**SSD 7484 MOD 4 - design changes to the Lands Building
Request for Additional Information**

I refer to the proposed modification for design amendments to the Lands Building at the Sandstone Precinct (SSD 7484 MOD 4). Further to the letter requesting a response to submissions dated 12 August 2019, the Department has considered the modification application further and is requesting that you provide the following additional information:

**Figure 8** | Historic carriageway route to be re-established in the northern and southern courtyards

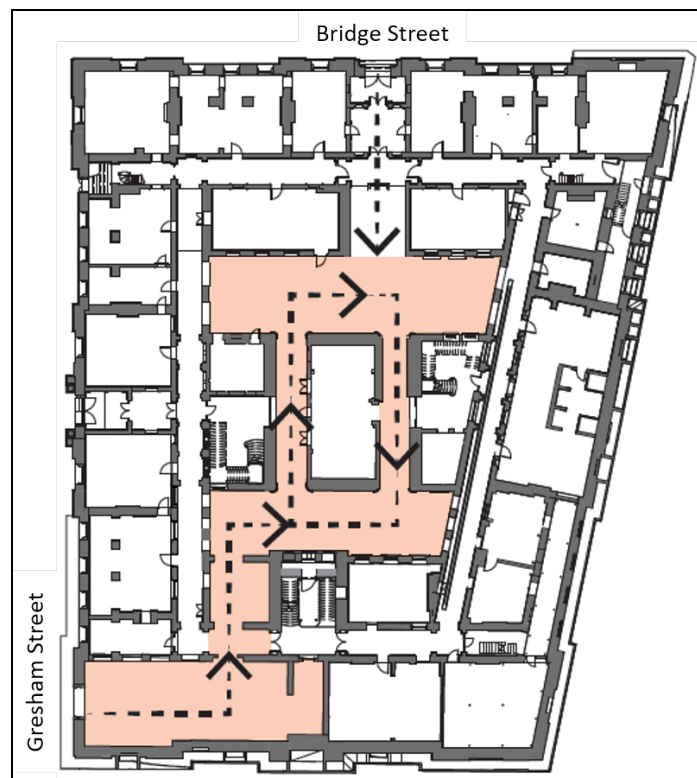
Elaborate on the conceptual landscape approach in the Design Report (pages 84 – 85) by providing an indicative landscape plan for the courtyard and terraces of the Lands Building, including:

- indicative plant species, noting the comments from EES Group about using native species
- changes in paving to identify the historic carriageway
- suitable soil depth or pots for planting
- further consideration of whether Condition B52 requires any changes.

**Figure 10** | Strong Room section showing proposed restored volume (left) and proposed demolition in red (right)

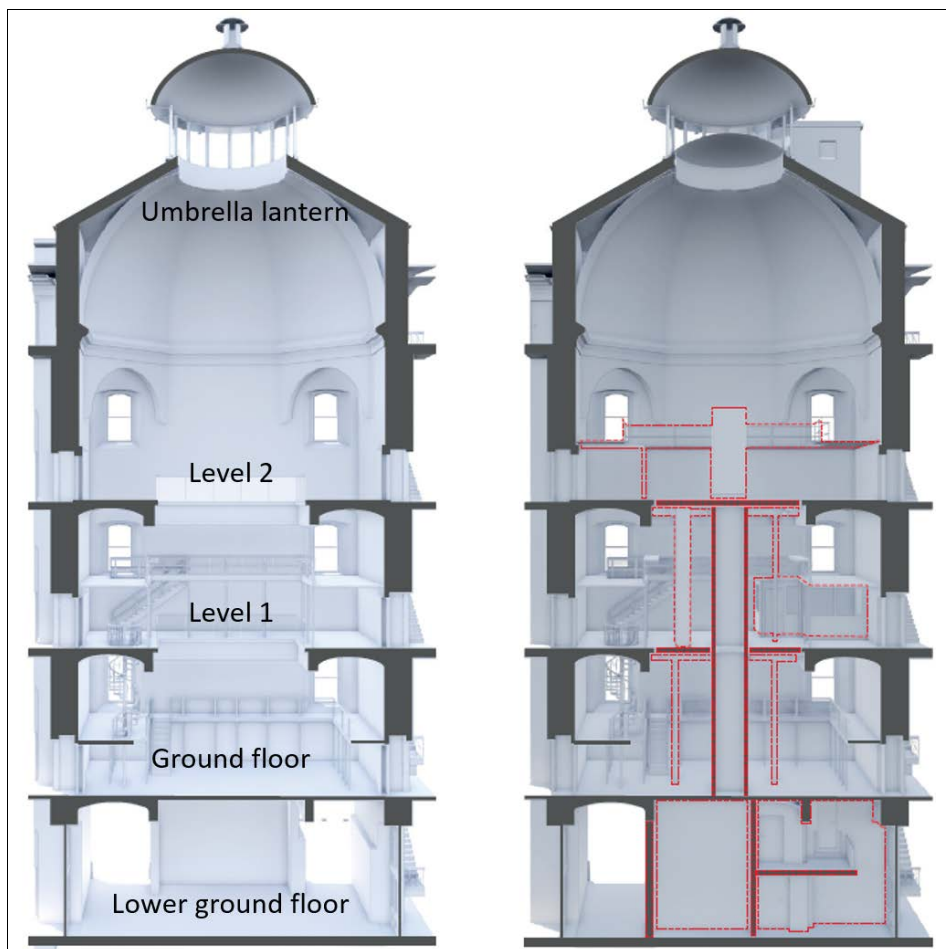
The Design Report indicates that the Strong Room will be returned to its original volume by removing floors and partitions added in the 1950's and be used as a reception, lounge, bar and function arrival space. I note a detailed strategy for demolition and conservation will be developed further, but it's unclear how and when this strategy will be secured and delivered.
